CAWSTON PARISH COUNCIL NORFOLK BOREAS OFFSHORE WINDFARM INQUIRY DEADLINE 16 SUBMISSION

Cawston Parish Council

27th September 2020

CAWSTON VILLAGE CENTRE - B1145
SCALE - 1:500

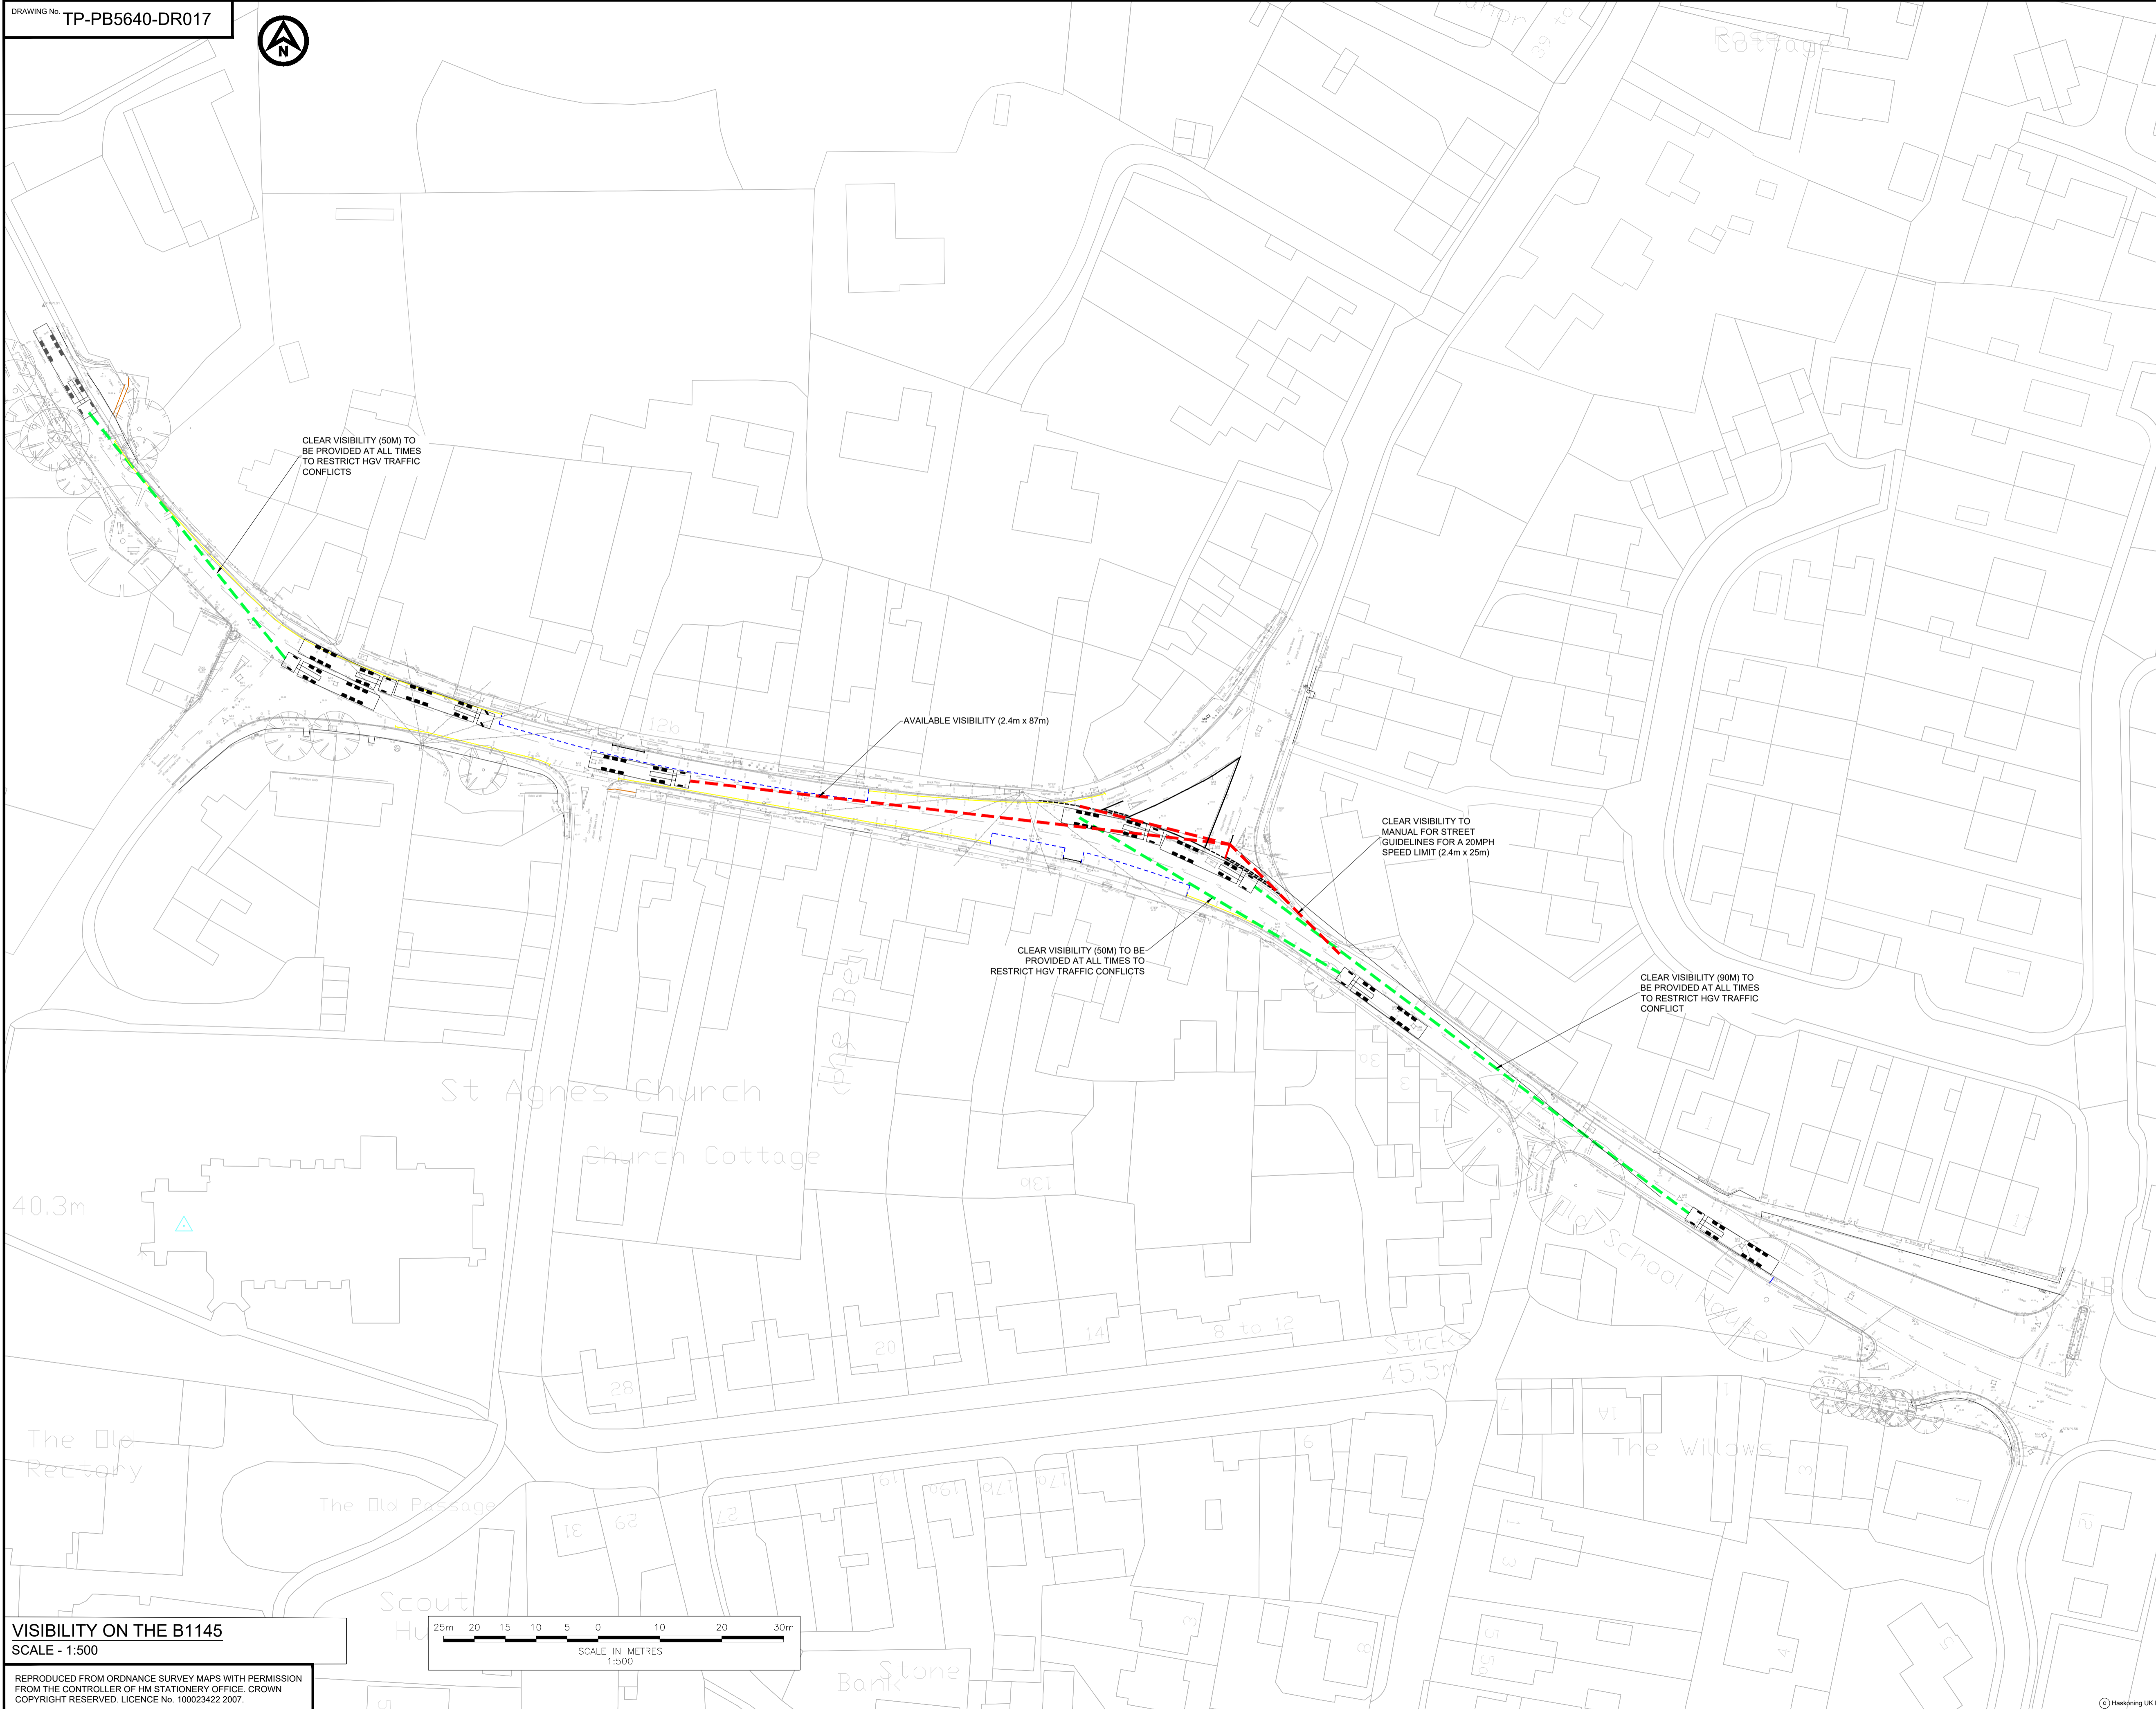
Elsewhere, in REP14-039 the Applicant states “ *There is a short section of the scheme in the vicinity of No.10 High Street that narrows to just over 5m wide after which the carriageway alignment flares out to an average of 5.6m wide. A private car in the UK measures in the range of 1.7m (compact hatch back) to 1.9m (large SUV). The HIS parking bays are sized similar to those applied to resident parking schemes and define a 2m wide box to encourage efficient use of road-space.*

We do not see what relevance an average width of 5.6m, without stating which length of road is being measured, has. Surely the key dimension is the width at the pinch points, which occur in many places along the B1145 from the B1149 roundabout to Salle Beck bridges.

While we quoted actual dimensions of cars owned by residents, the Applicant makes general statements without sources. A review of small hatch backs on *automobiledimension.com* found base widths all in excess of 1.7m, with mirrors typically adding around 200mm. Similarly, most large SUVs had a base measurement in excess of 1.9m, with mirrors taking them to around 2.2m (for example, see the Range Rover, 1990/2220mm).

The Applicant goes on to state “*the scheme meets the design principle of providing adequate road space for HGVs to traverse the High Street without the requirement to mount or project over the pavement.*” One can only assume that the author was not present at any of the ASIs where this was seen to happen many times. There is a world of difference between box ticking computer models where mirrors on cars and HGVs can overlap and vehicles pass safely with just millimetres of space, and the reality of life on the ground.

The extensive series of swept path diagrams the applicant claimed to demonstrate the supposed safe passage through Cawston of their HGVs (of a 2.25m track width fitted with miraculously non-protruding, presumably ineffective, wing mirrors). The applicant has yet to produce swept path diagrams for the accompanied Hornsea 3 Abnormal Loads with their 3.3 metre wide load. Such an analysis would identify additional and extended “*potential two way HGV conflict areas*” identified in Norfolk Boreas Offshore Wind Farm Outline Traffic Management Plan Appendices Part 1 of 2 (Version 6) The extended HGV conflict areas, together with the impact of any convoy system operated by Hornsea 3 exacerbating the existing problem of “*platooning*” of HGV and other traffic, will render the core concept of the Highway Intervention Scheme even less feasible.

The CPC figures quoted are for a large SUV with both wing mirrors fully extended. The parking bays are sized to encourage parking close to the kerbline (a behaviour that can be observed in current conditions) thus negating the influence of the wing mirror on the HGV path.”
